Principal Areas of Disagreement Summary Statement (PADSS) from Reigate & Banstead Borough Council			Version Number: V1.0 Submitted at: 26 October 2023	
	Principal Issue in Question	Concern held	What needs to change/be amended/be included in order to satisfactorily address the concern	Likelihood of concern being addressed during Examination
	PROJECT SITE & DESCRIPTION

Figure 11. Departure simulation results and August 2018 actual

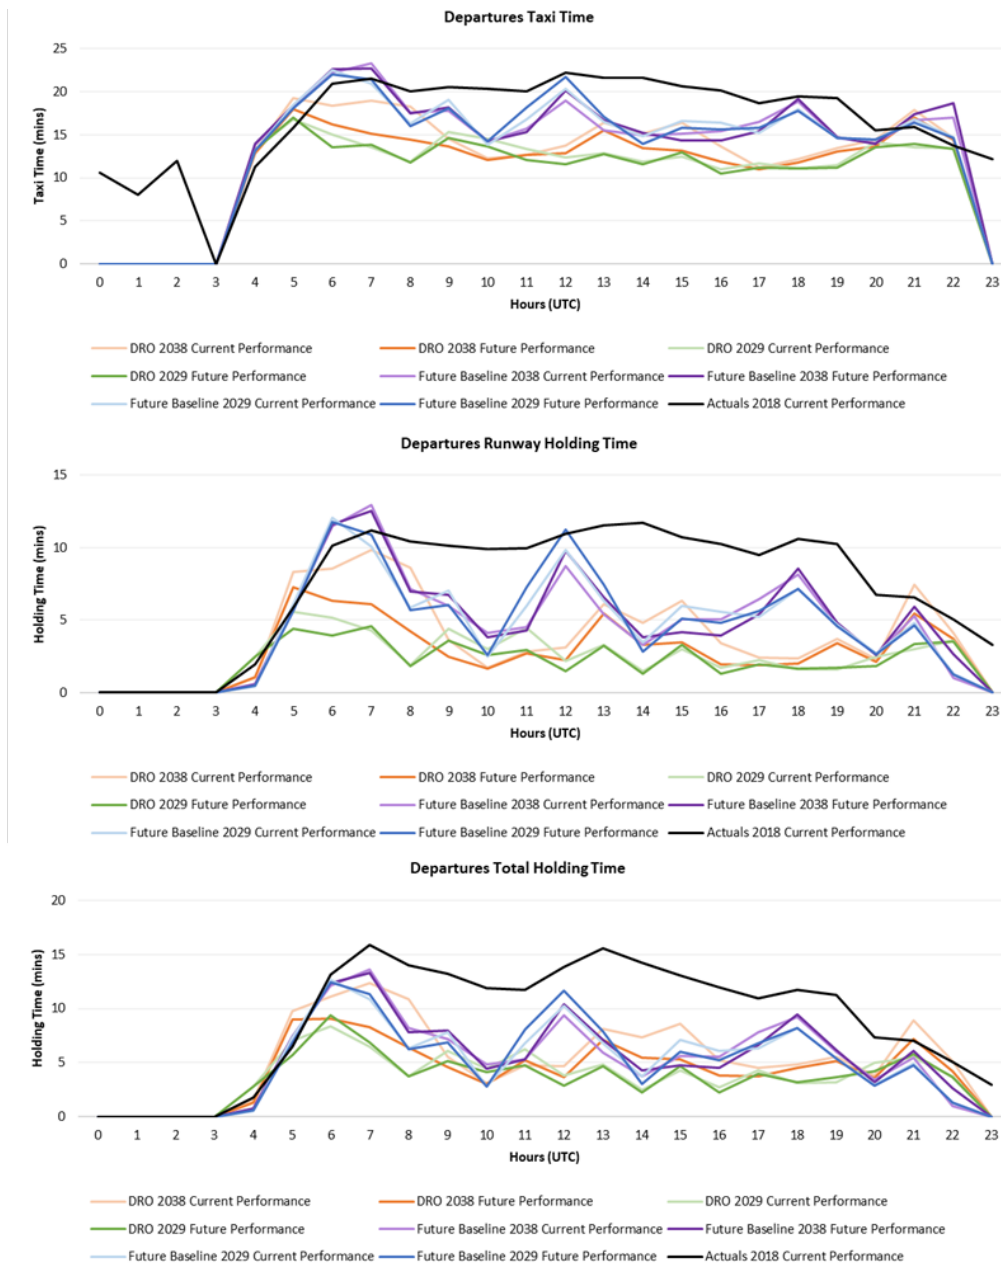
3.	The capacity deliverable with the NRP	Modelling by GAL of the capacity deliverable with the NRP has assumed that 1 minute separations can be achieved between all departing aircraft using the two	Full modelling of the interaction	Likely – subject to GAL transparently

Proposed Development	runways. This is not possible with the existing structure of SIDS, particularly given the commitment not to use WIZAD SID in the night period, and so additional delays to aircraft will arise so increasing delays above those stated in the Application documents. Consequently, the achievable capacity, at a level of delay acceptable to the airlines, will be lower than stated.	between the use of the two runways and the respective departure routes needs to be undertaken and the delay information provided at a sufficiently granular level (hourly) to enable the delays to be properly understood and the capacity attainable validated.	undertaking and sharing the relevant simulation modelling.

Section 13 - A23 London Road (River Mole To New Signal-Controlled Junction)

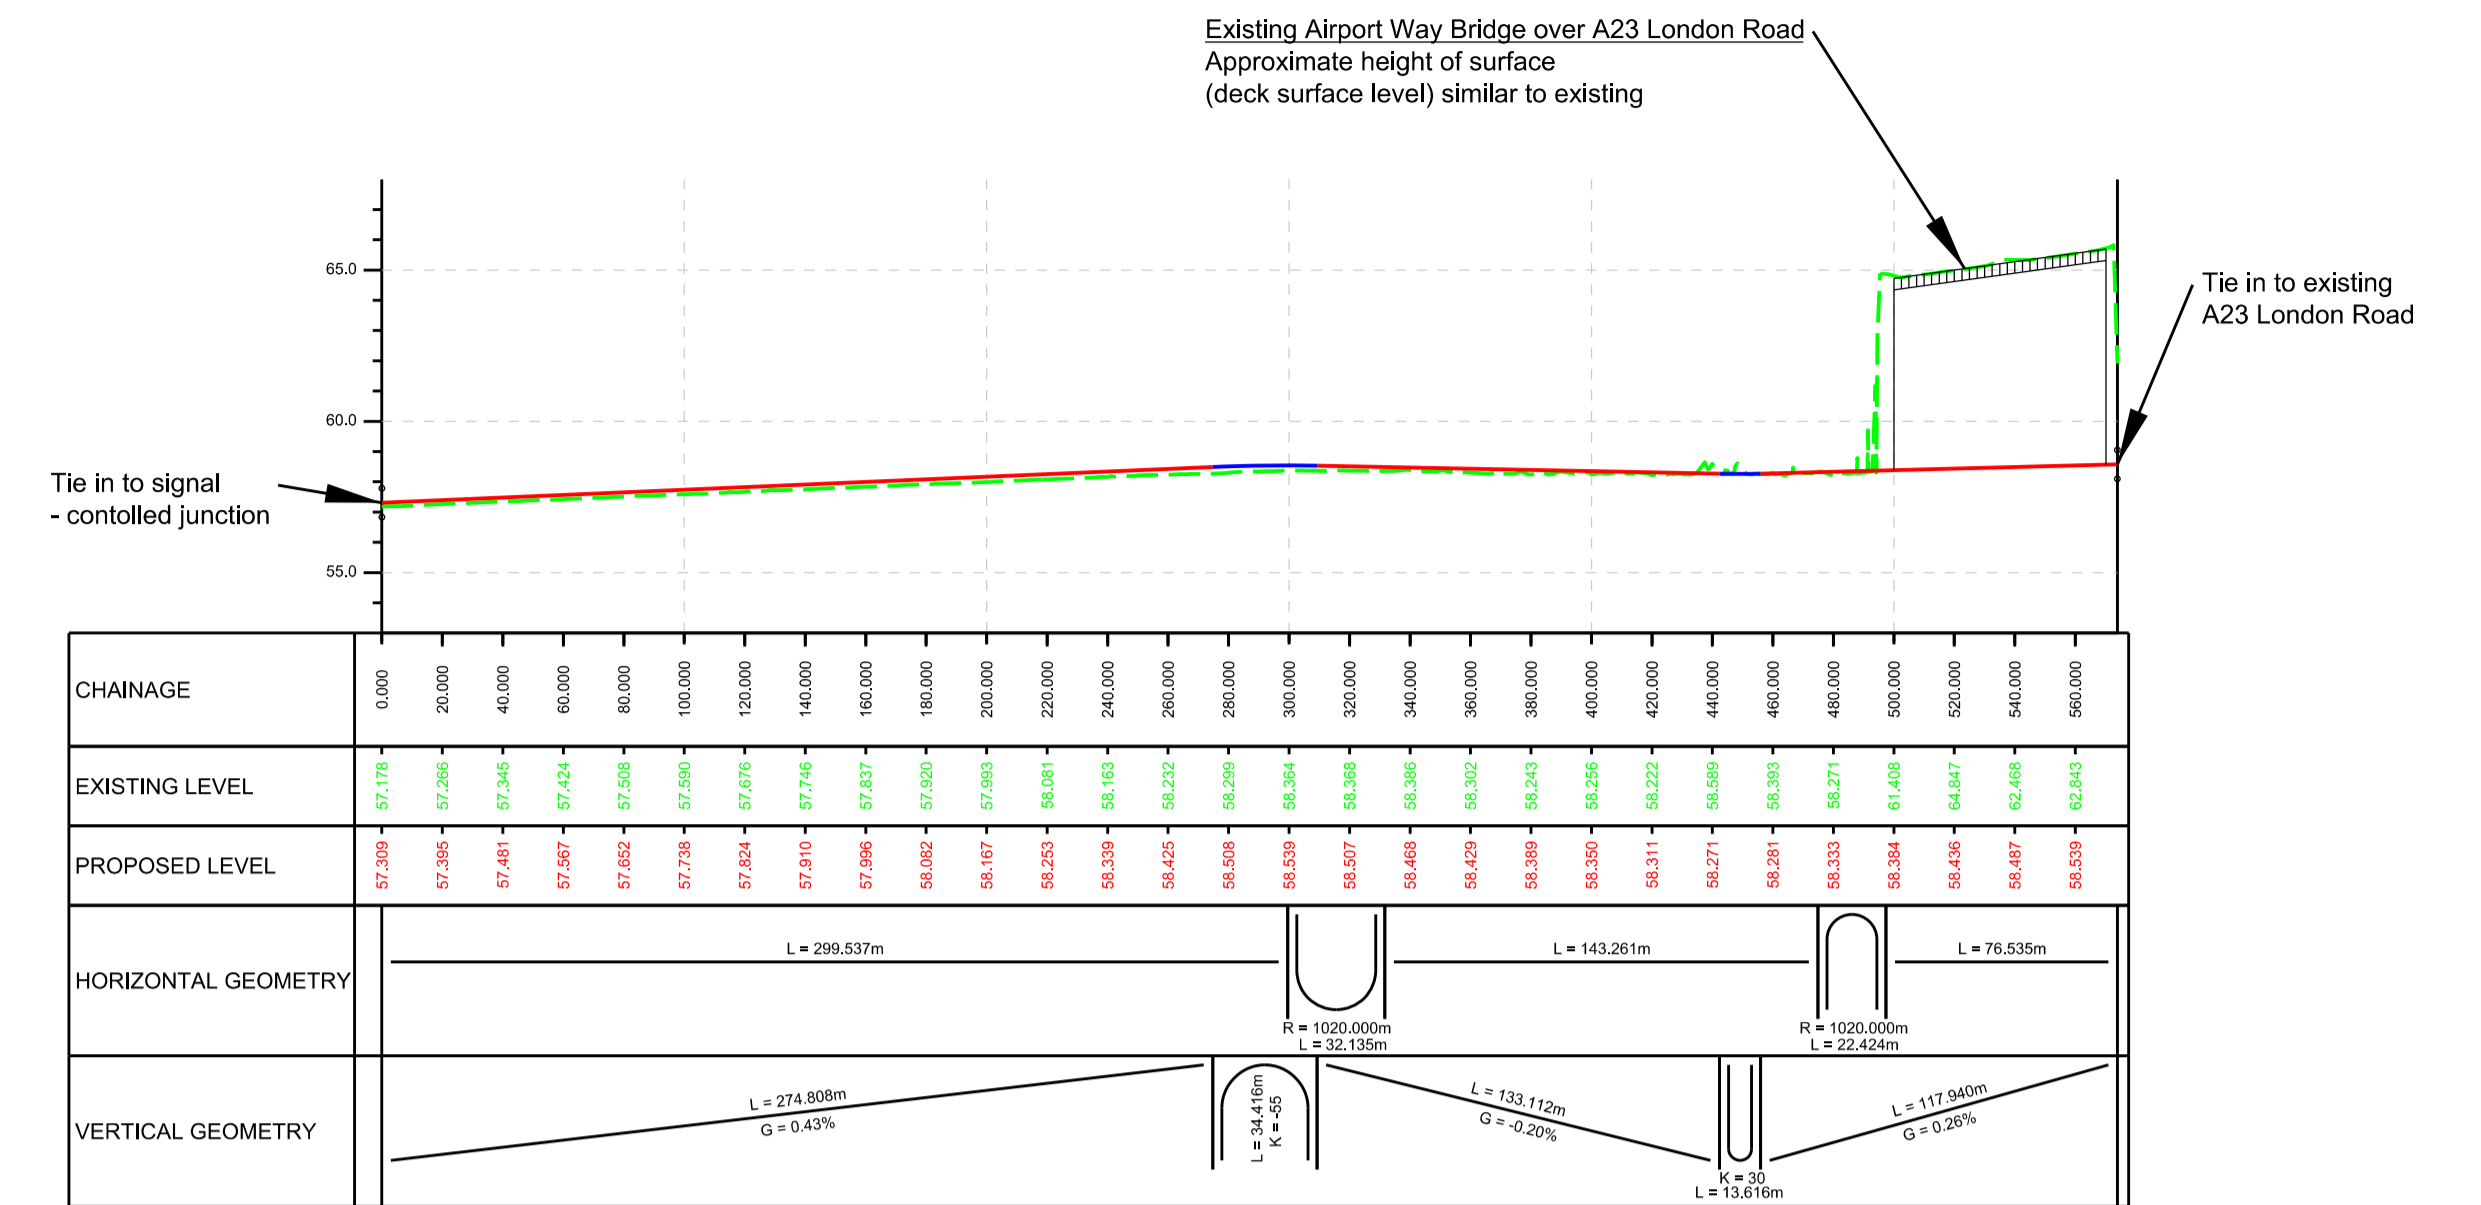
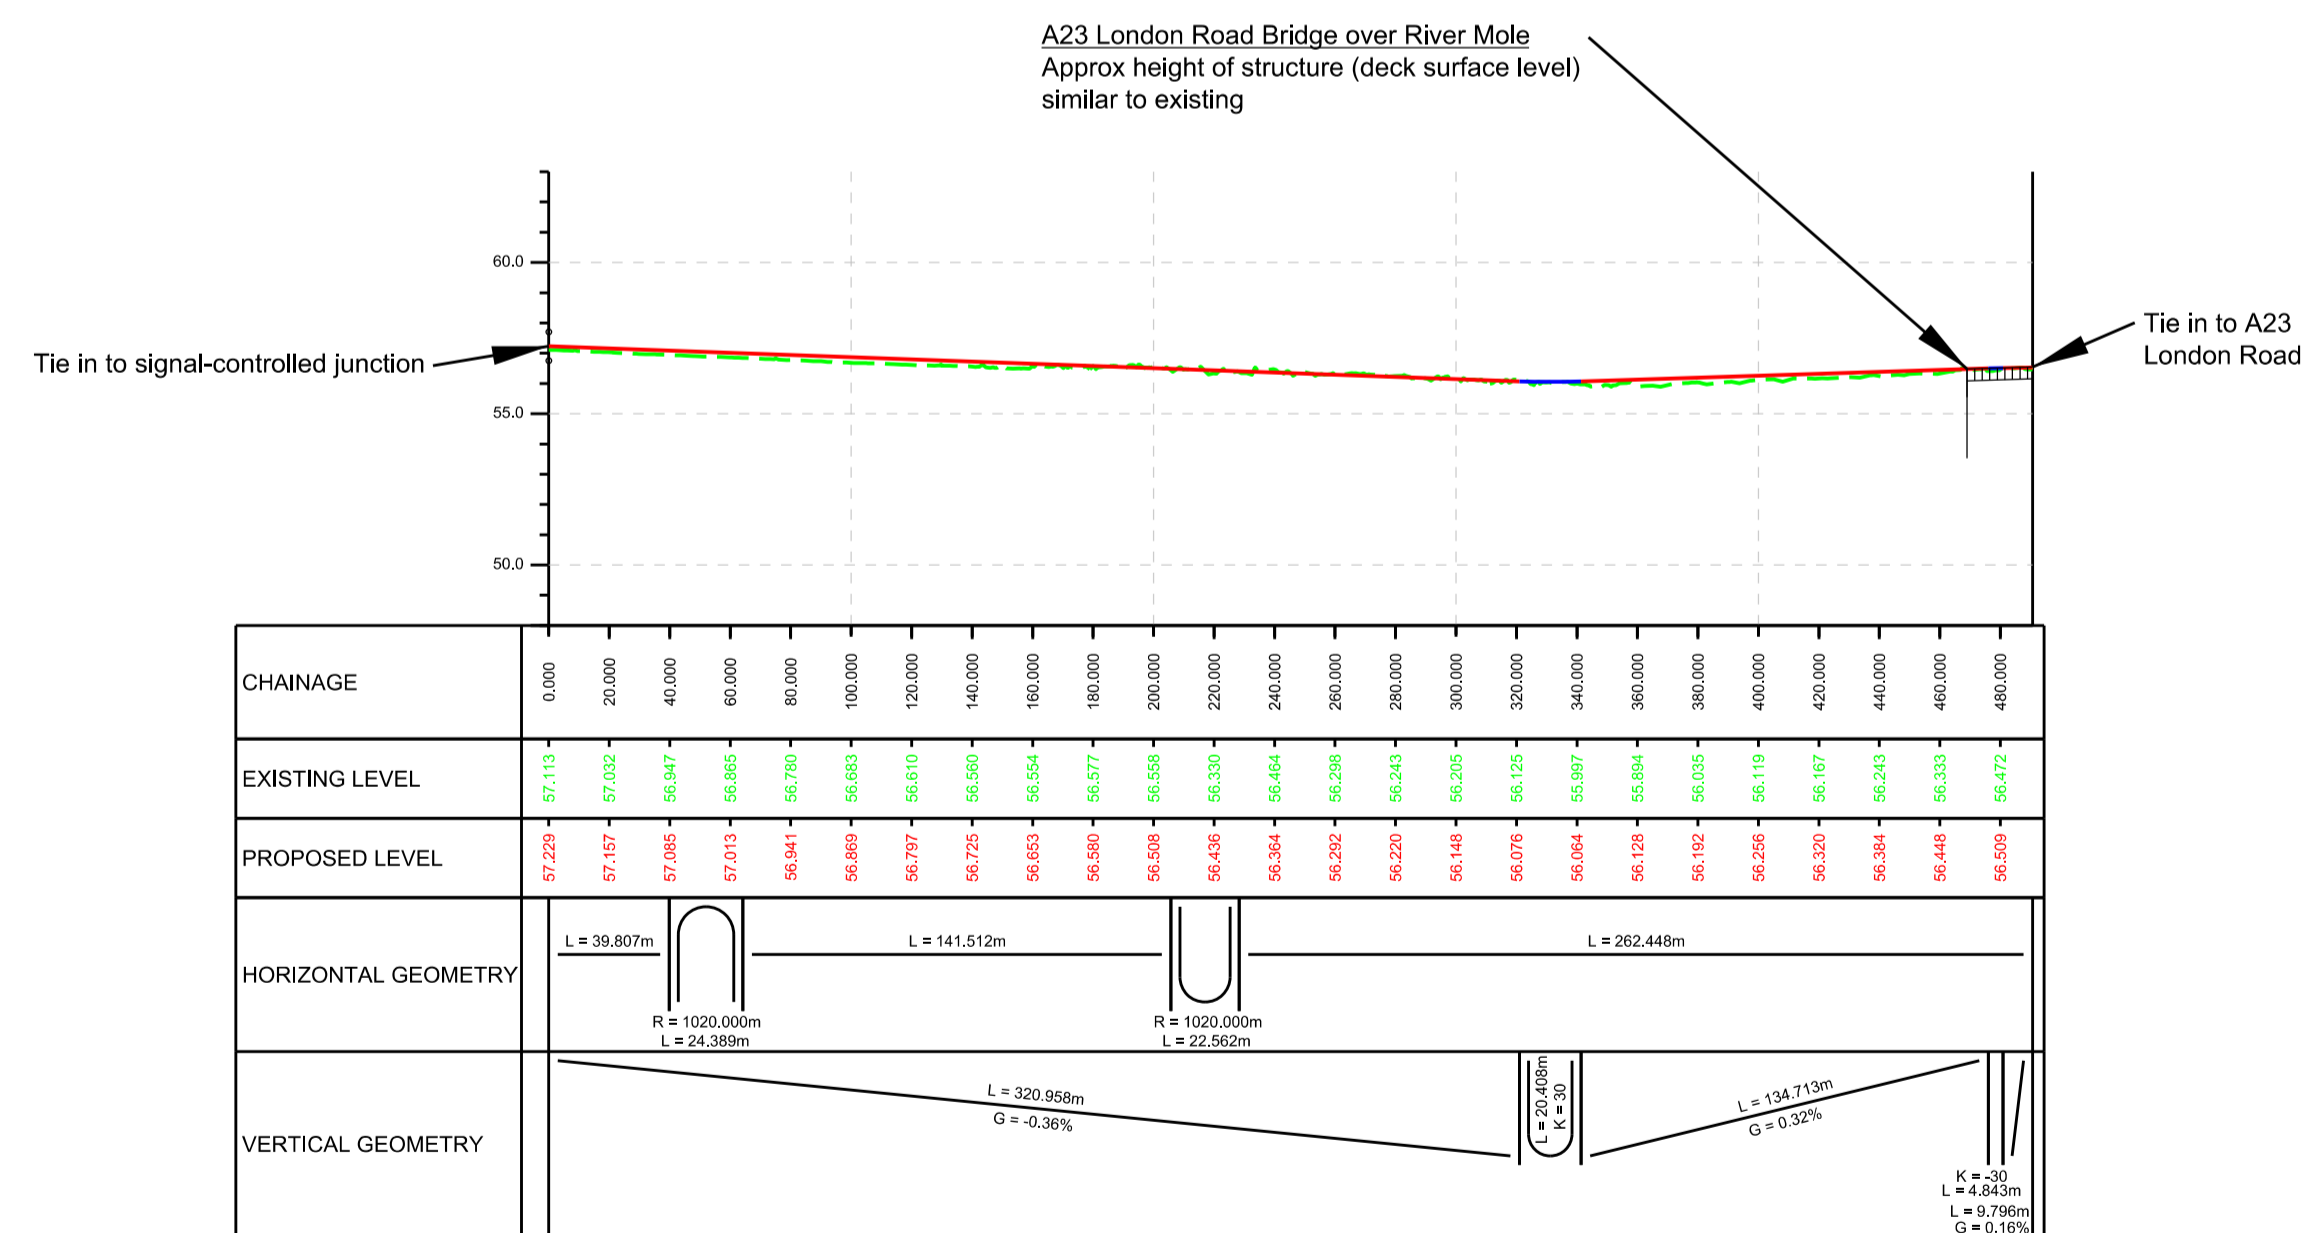
ensure that local communities are benefitting from having an enlarged Gatwick on their doorstep.	
	HISTORIC ENVIRONMENT			
8.	Impact of the A23 London Road/River Mole bridge and road widening on the Listed St Bartholomew's Church and conservation area and historic Church Meadows	Relates to the visual impacts of the works on the listed church and conservation area	Consideration of alternatives to reduce land take from Church Meadows	Uncertain
	ECOLOGY
